Address: 25 Woodhead Road Holmfirth HD9 2JU

Application number: 2023/91491	
What is the application for?:	Erection of 61 age-restricted apartments with ancillary accommodation including
Address of the site or building:	Prickleden Mills, Woodhead Road, Holmfirth, HD9 2JU
Postcode:

Type of comment: An objection	
Do you wish your comments to be published on the website anonymously?	No
<p>We are writing to object to the planning application lodged at Prickleden Mills ref:2023/91491</p> <p>1. Kirklees Councillors and officers rightly refused application number 2021/62/92003/W from the same applicant and their design team. The five reasons for refusal of that application have not been addressed by this submission, and all remain applicable, and should be cited as reasons for refusing this application. The lack of considered and meaningful changes to the design to address the reasons for the refusal, is well illustrated by extensive usage of the same drawings, which still bear the 2021 dates they bore when submitted in support of the refused application.</p> <p>2. Its immense scale and massing will cause significant harm to the Conservation Area in Contravention of the National Planning

Description
SECTION J-J

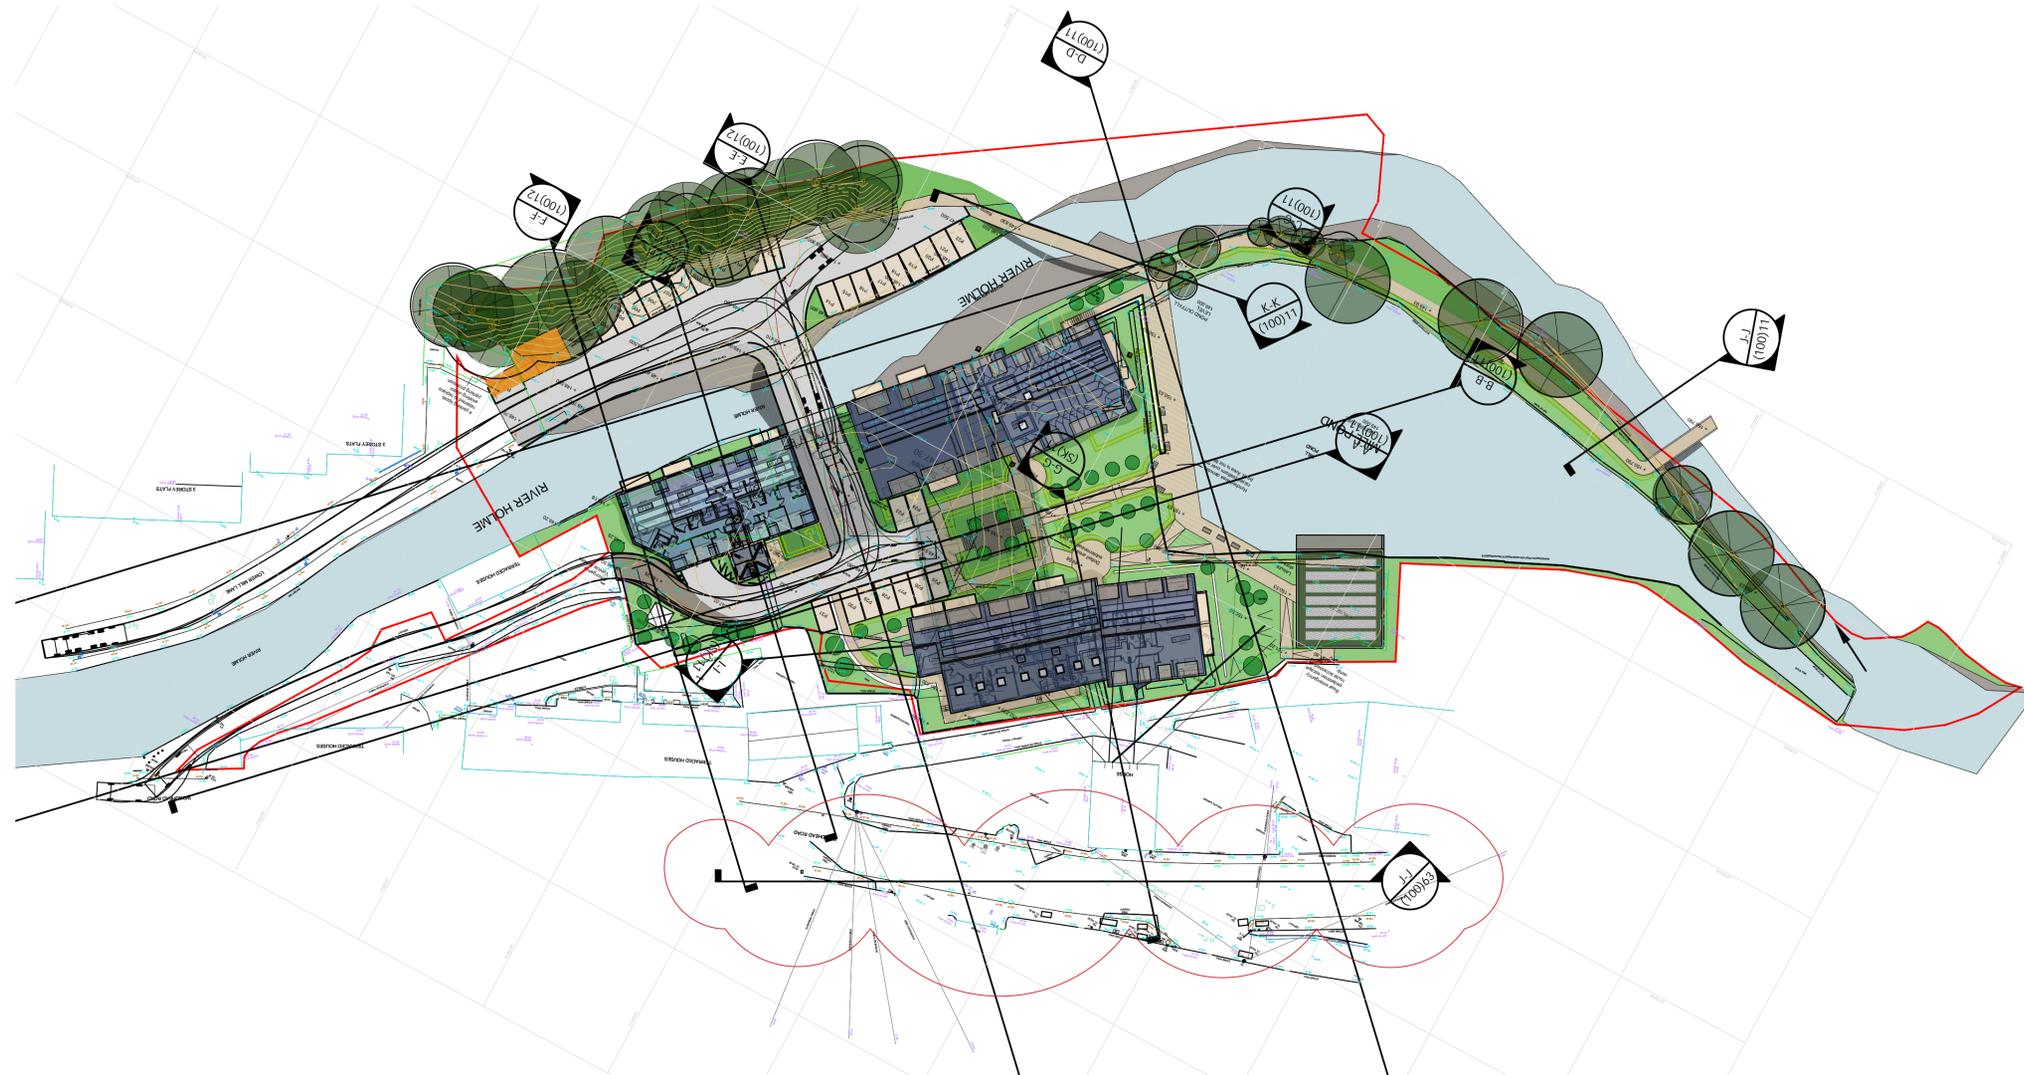
5. The eaves height of the revised proposal in places is up to 170m AOD making it in places 3 storeys higher than the consented scheme. . Some of the buildings proposed will exceed the height of the Listed Buildings at 25-27 Woodhead Road which will be dwarfed and obscured by these revised proposals in further offence to policy LP35.

ROOF PLAN

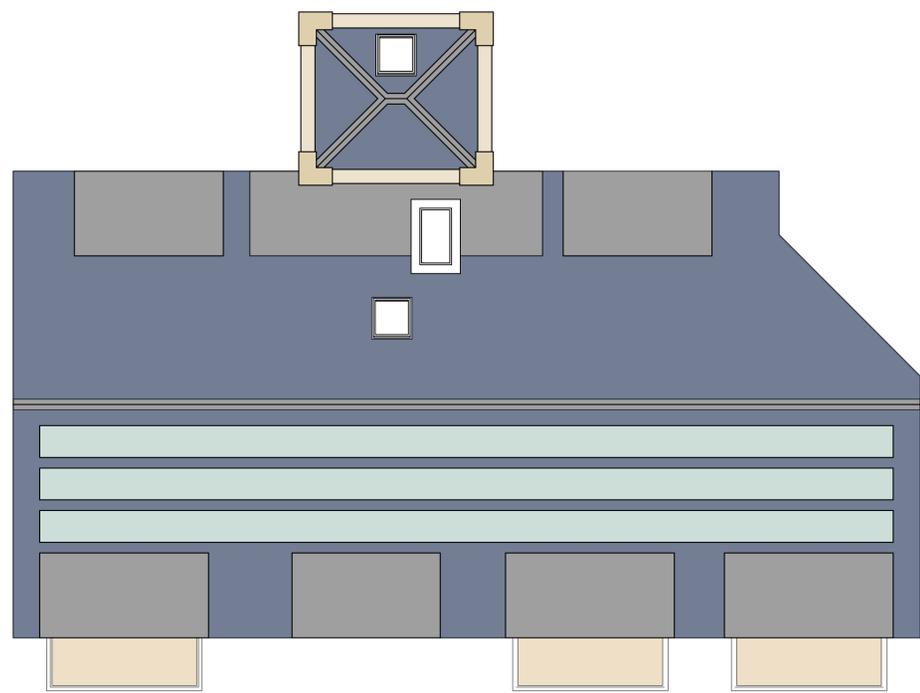
(b) It does not promote high levels of sustainability

SECTION LINE LOCATIONS

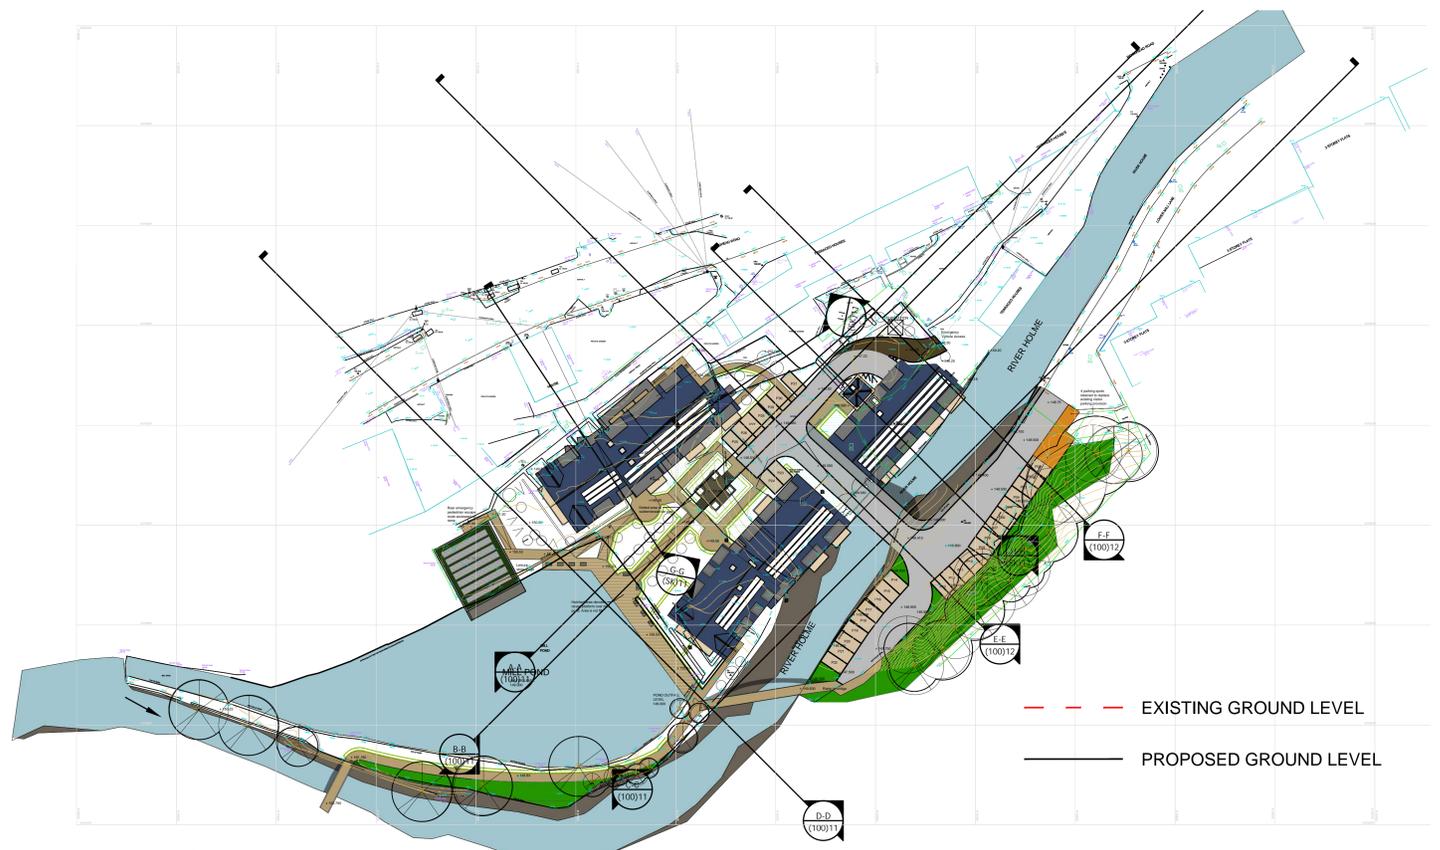
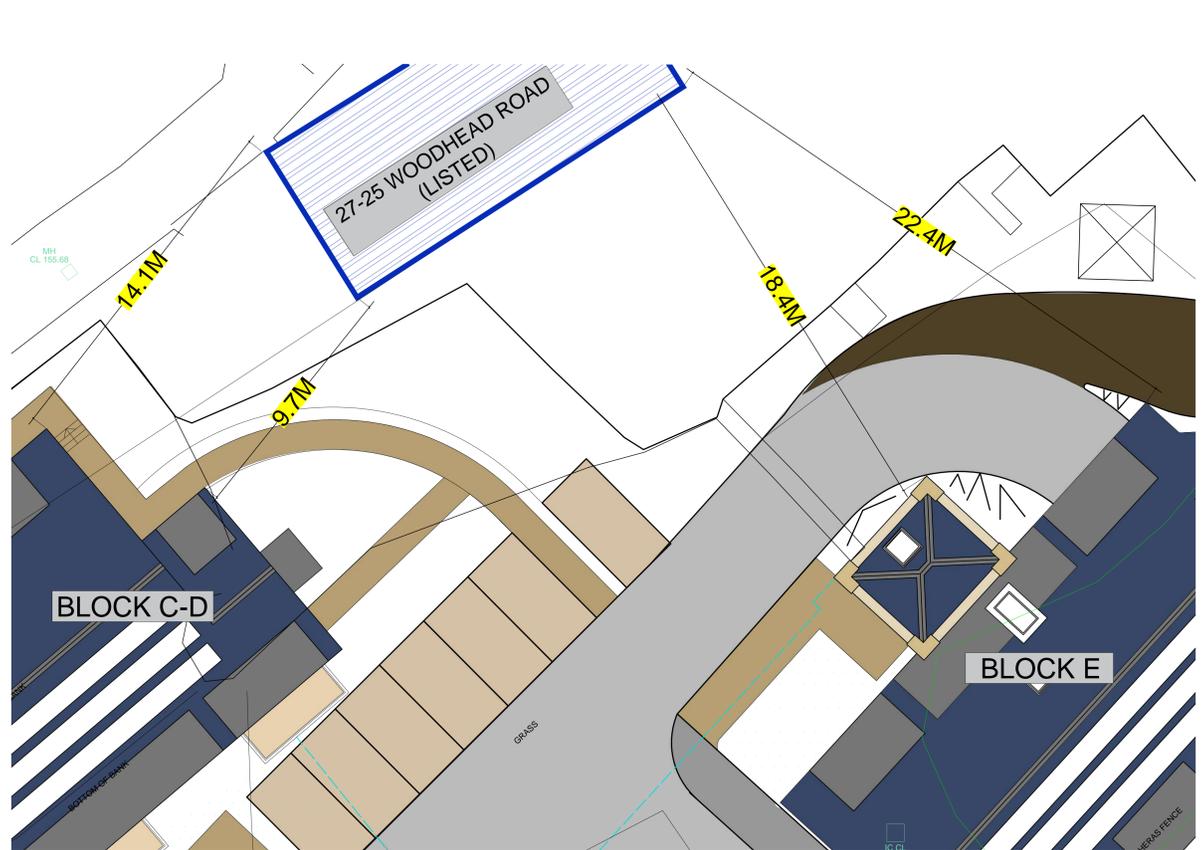
6. The existing ground level is proposed to be raised by up to 3m to accommodate underground car parking . Aside from exacerbating the problems of height, scale and massing of the proposals, this is in contradiction to policy LP20 for Sustainable Travel with its prioritisation of private vehicles in direct contravention of the policies set out in the hierarchy in the policy itself.

10. The proposal may be in breach of policy LP28 Drainage. The developer should be required to demonstrate outline proposals on how SuDS will be implemented , and should not be permitted to raise the Ground levels and especially not by the enormous amounts shown in the plans.
